Project Name: Piasecki Amended Plat

Project Number: SF 1917

Description: The property owners of Lot 6 and 8 of Cathedral Pines Subdivision #3 are requesting a vacation & replat of Lot 7 adding area to both Lot 6 and Lot 8 forming a new Filing. The addresses of these lots are 4820, 4860 and 4940 Foxchase Way.

## AS RE-PLATTED

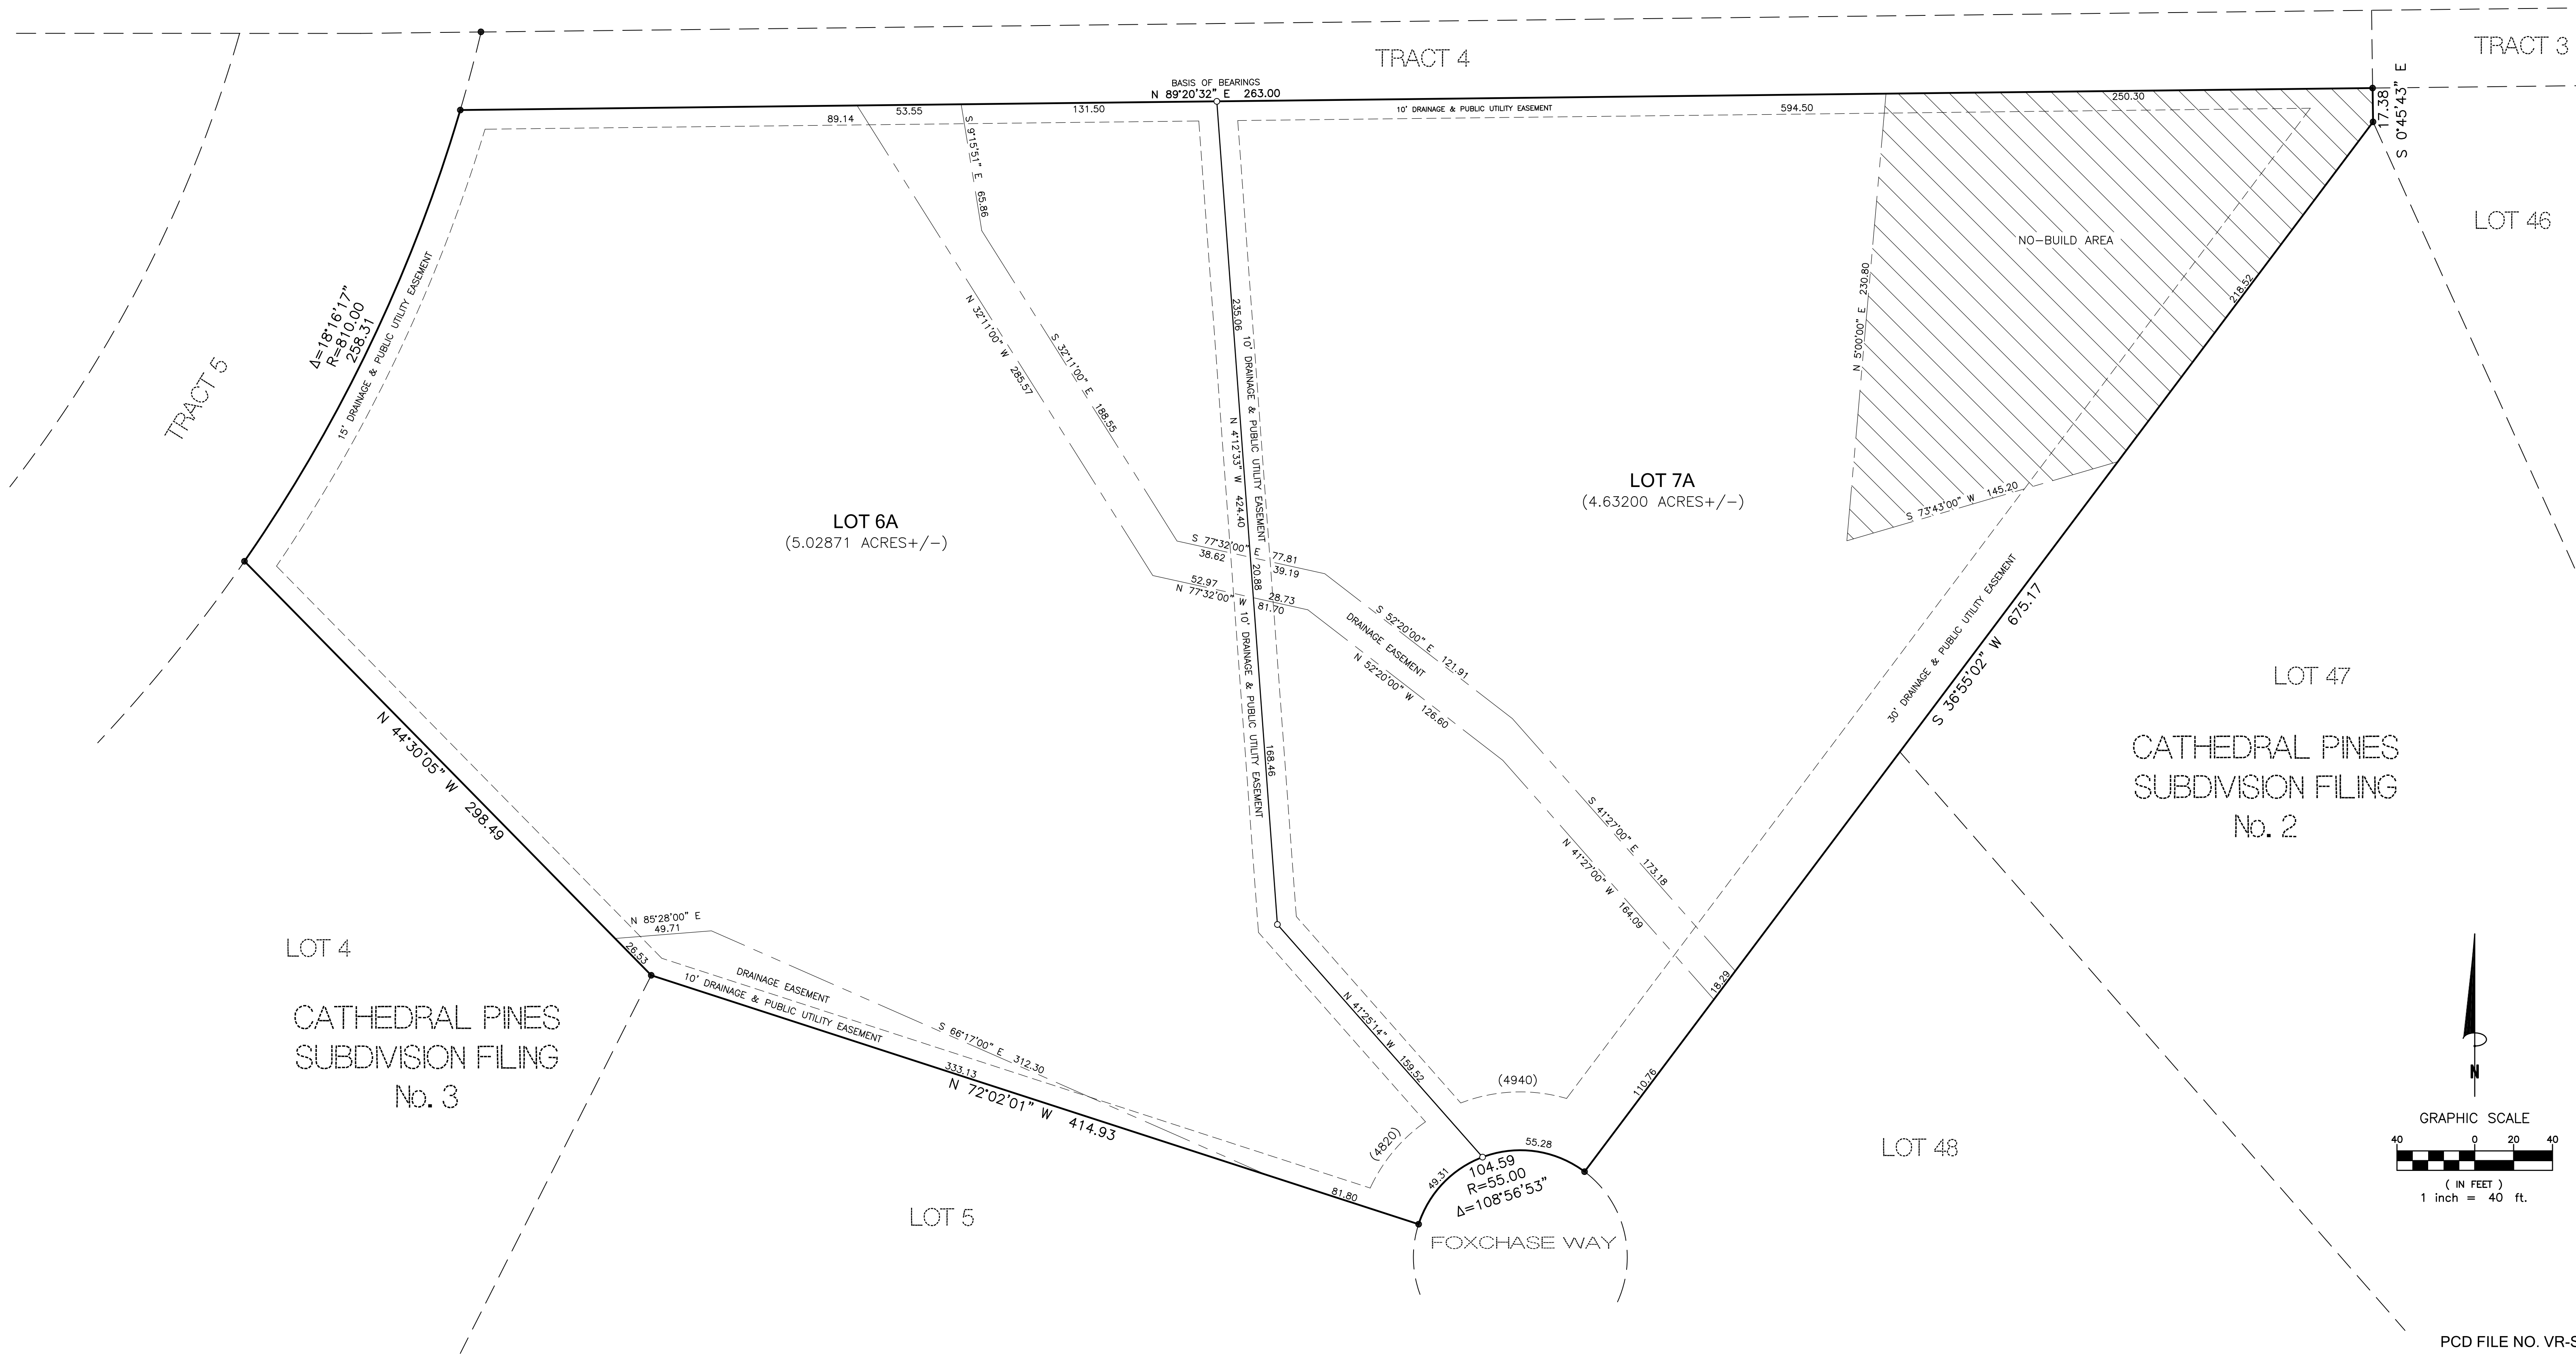
MVEA has designed and build the electrical facilities in this subdivision according to the recorded final plat of Cathedral Pines Subdivision #8. By adjusting the lot lines of Lots 6-8 the electric facilities will no longer be located on the common side lot lines of these residential lots. This lot line adjustment could leave facilities such as pedestals and transformers in an inconvenient location for the homeowner. If there is any removal or relocation of facilities to accommodate the redesign it will be at the expense of the applicant.
